From: Jean Fraser
To: Will Savage
Date: 1/21/2016 4:18 PM
Subject: Prelim review comments 31 Fore St
Attachments: R6 Infill.doc

The following comments are from a preliminary review of the proposal at 31 Fore Street under the R-6 Infill Development Design Principles & Standards:

DRAWING NO.
SP-1

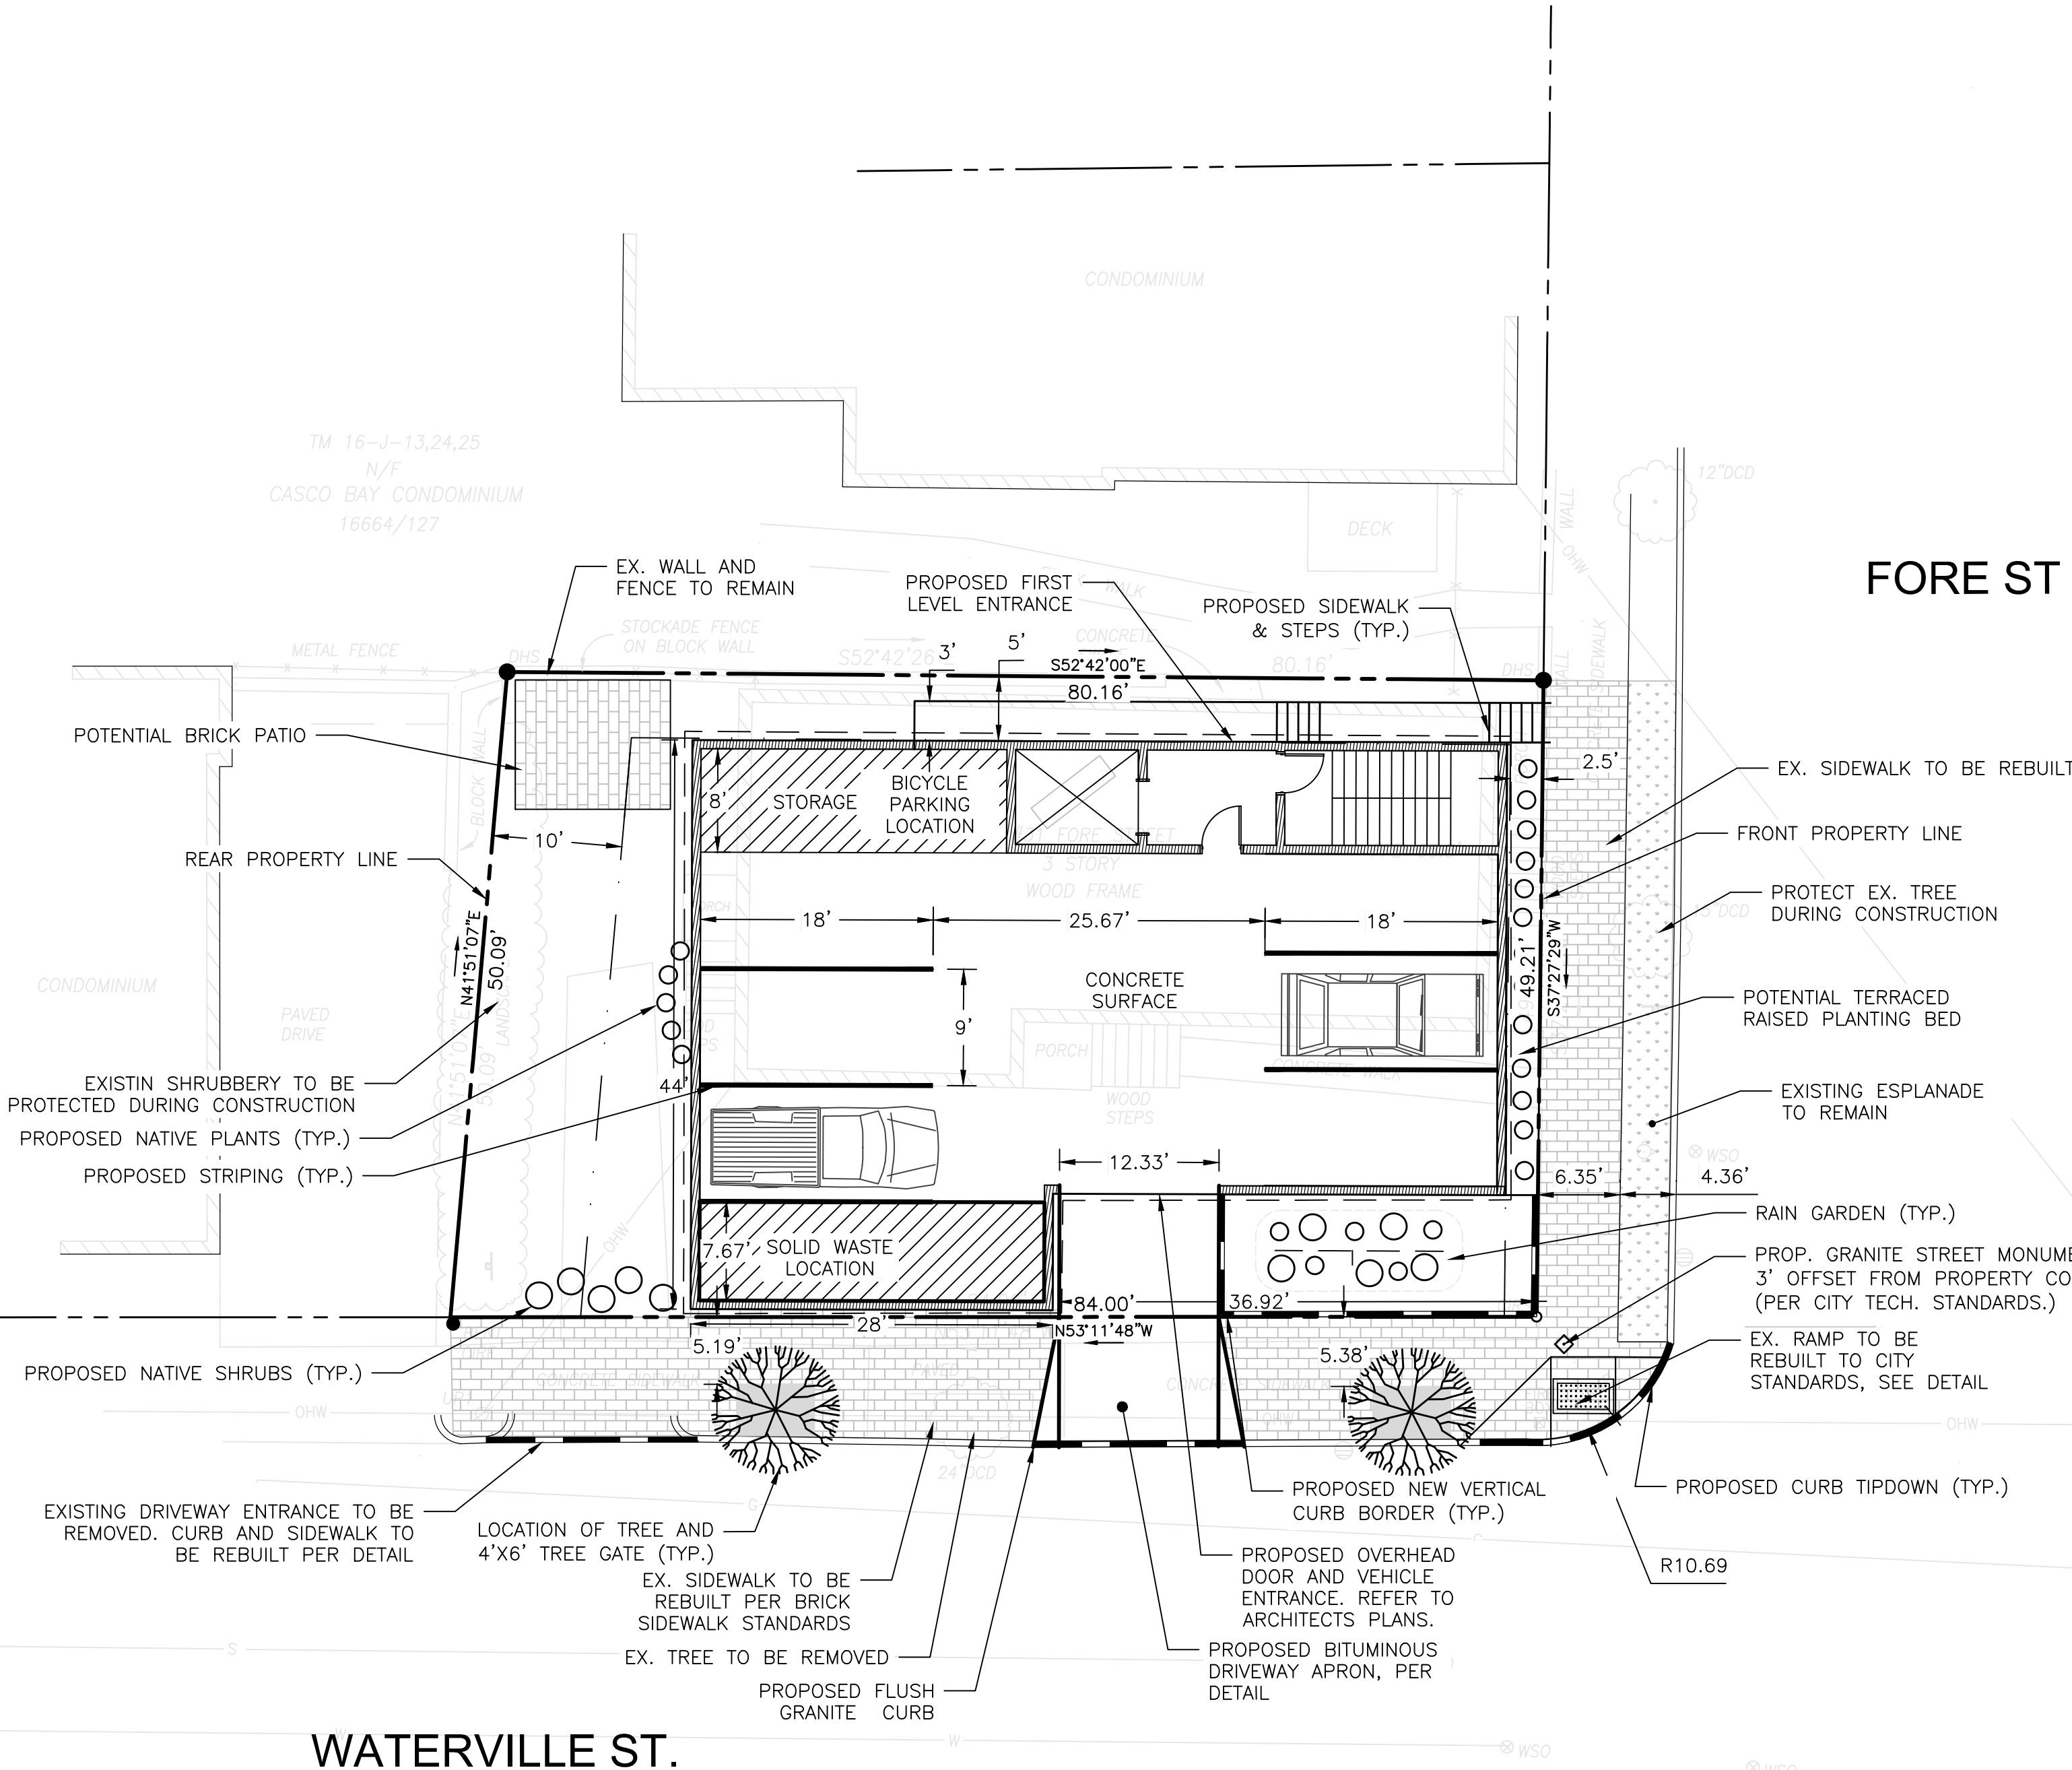
Draft Subdivision Plat: the submitted draft needs revisions to meet the ordinance requirements and I will send review comments when available; revisions to the plat can be done at the final review stage, so this is a lower priority issue but I wanted to mention it.

DRAWING NO. **L-1**

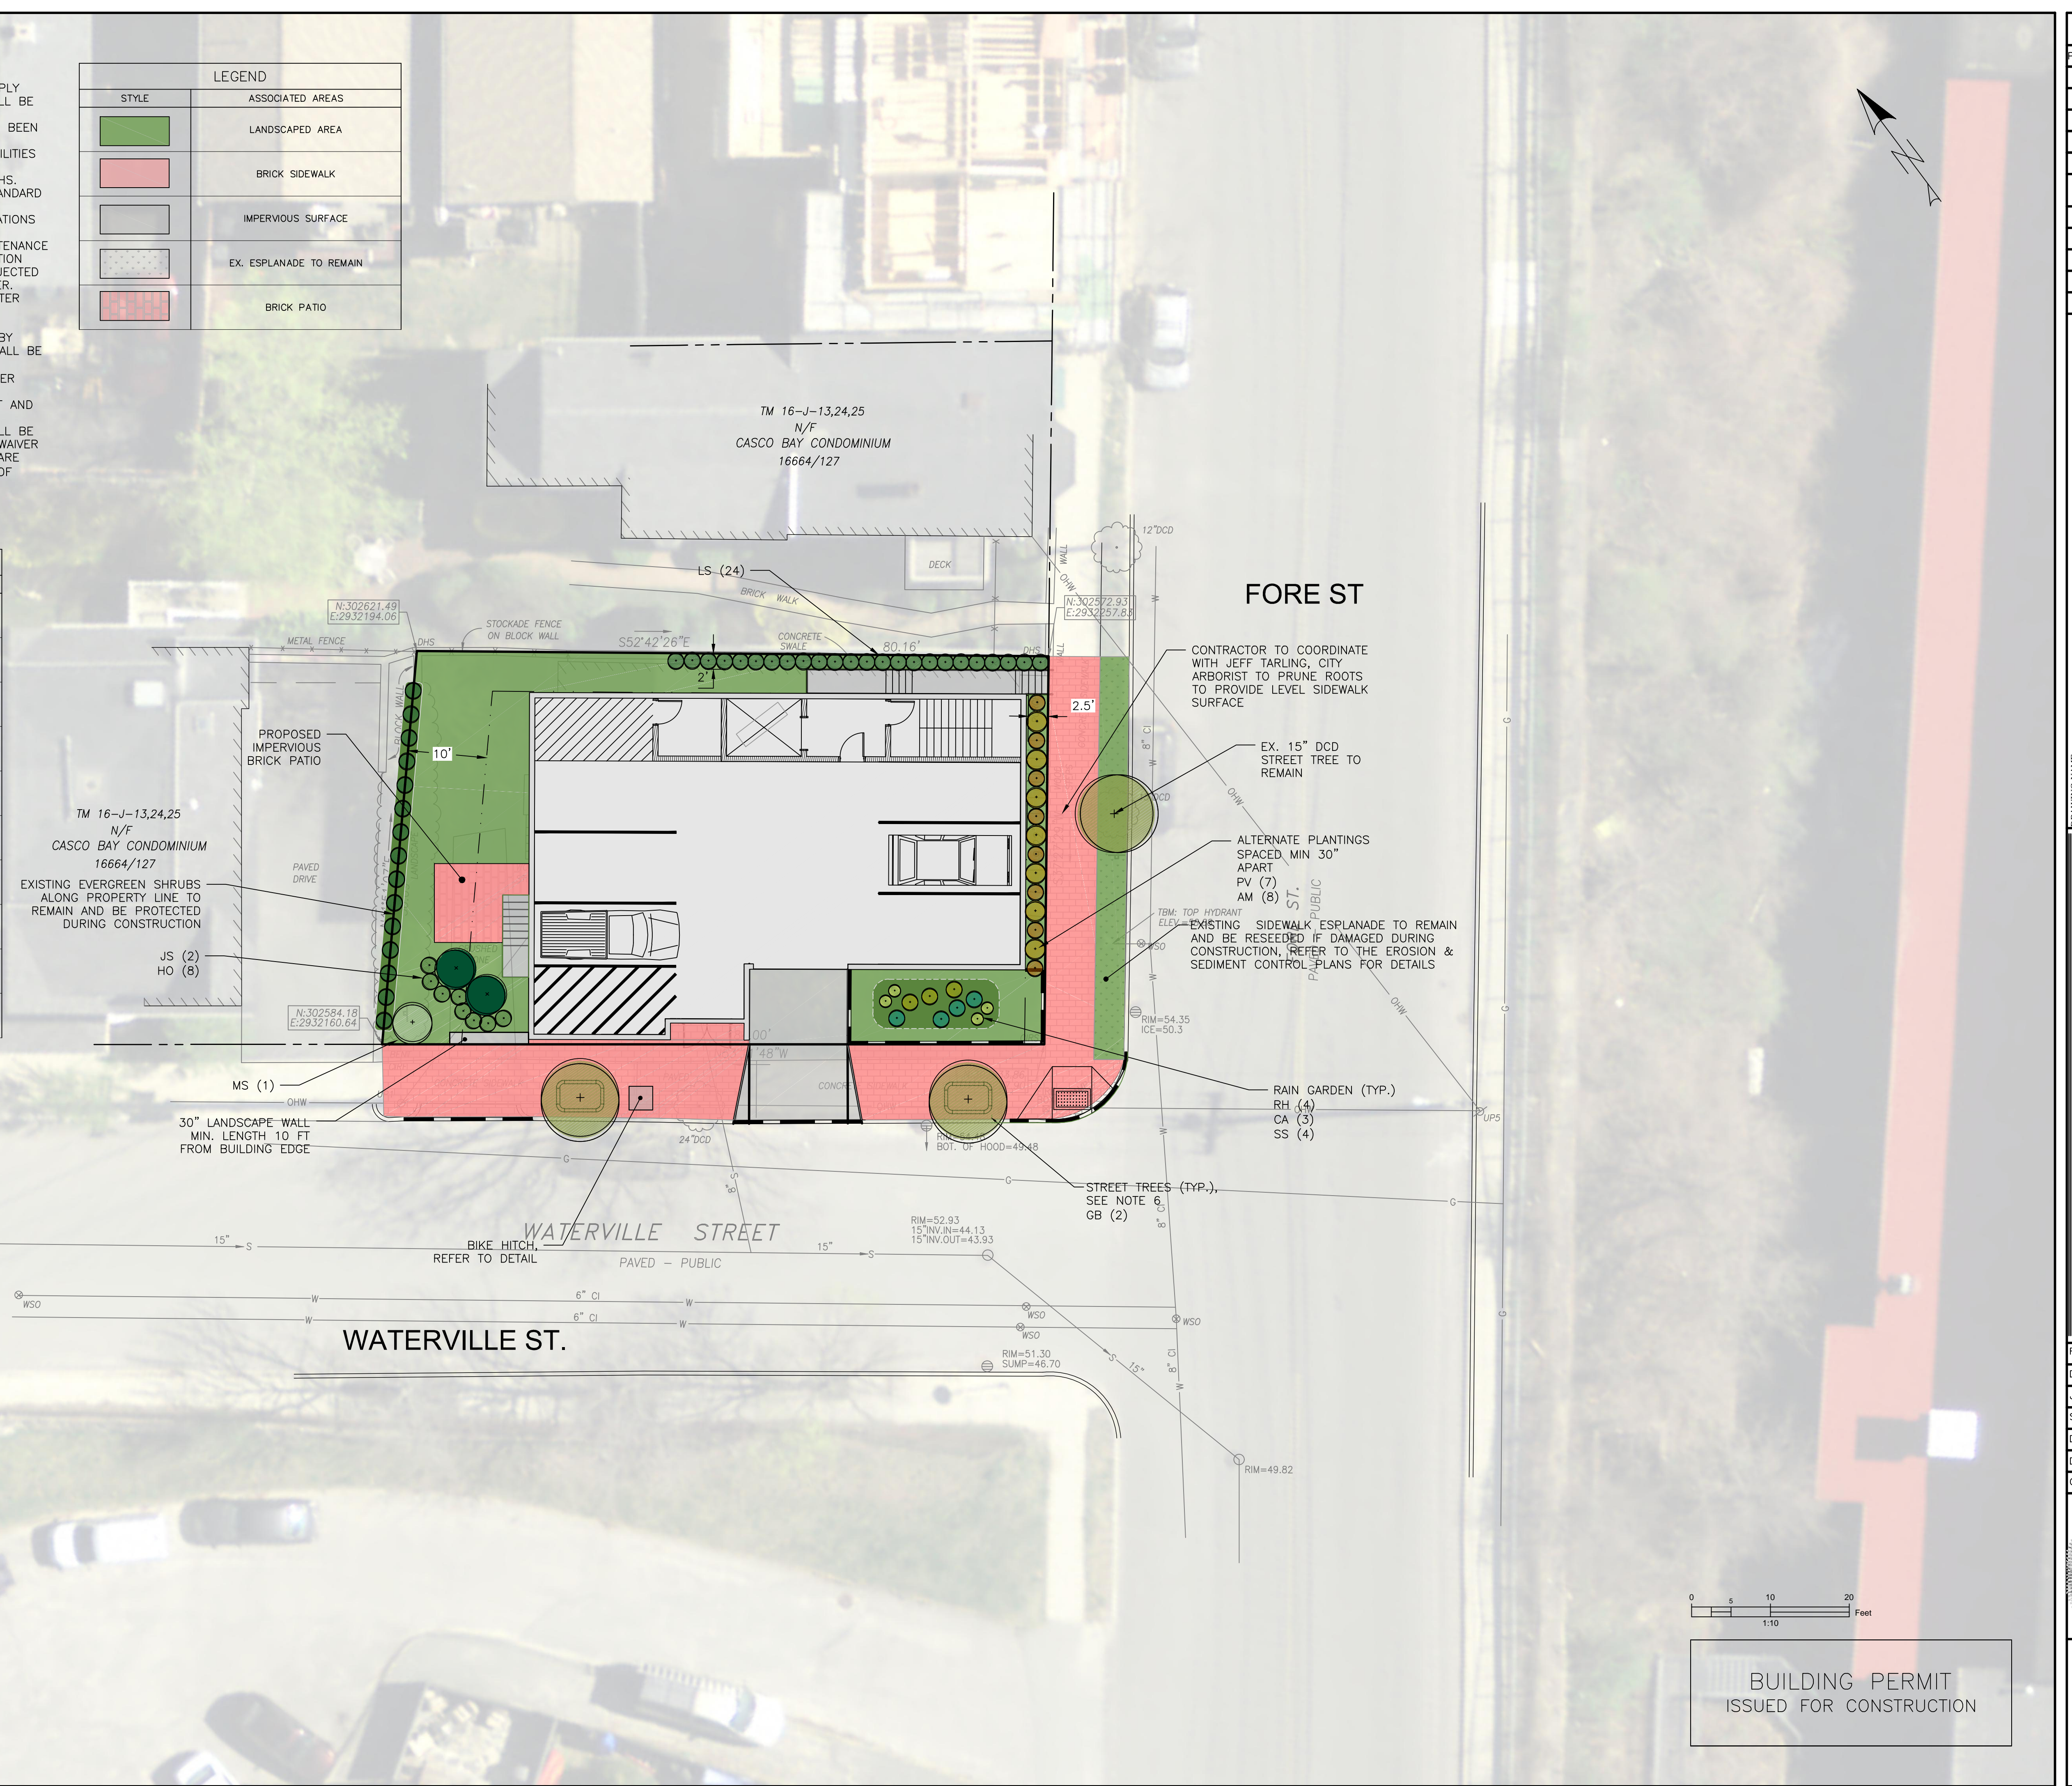
Landscaped Open Space: *20%. This area shall not include parking areas or other impervious surfaces as defined in section 14-47.* (so the brick patio needs to be subtracted if impervious; please show calculations) (Plan needs to show all landscape including grass)

Is patio impervious?
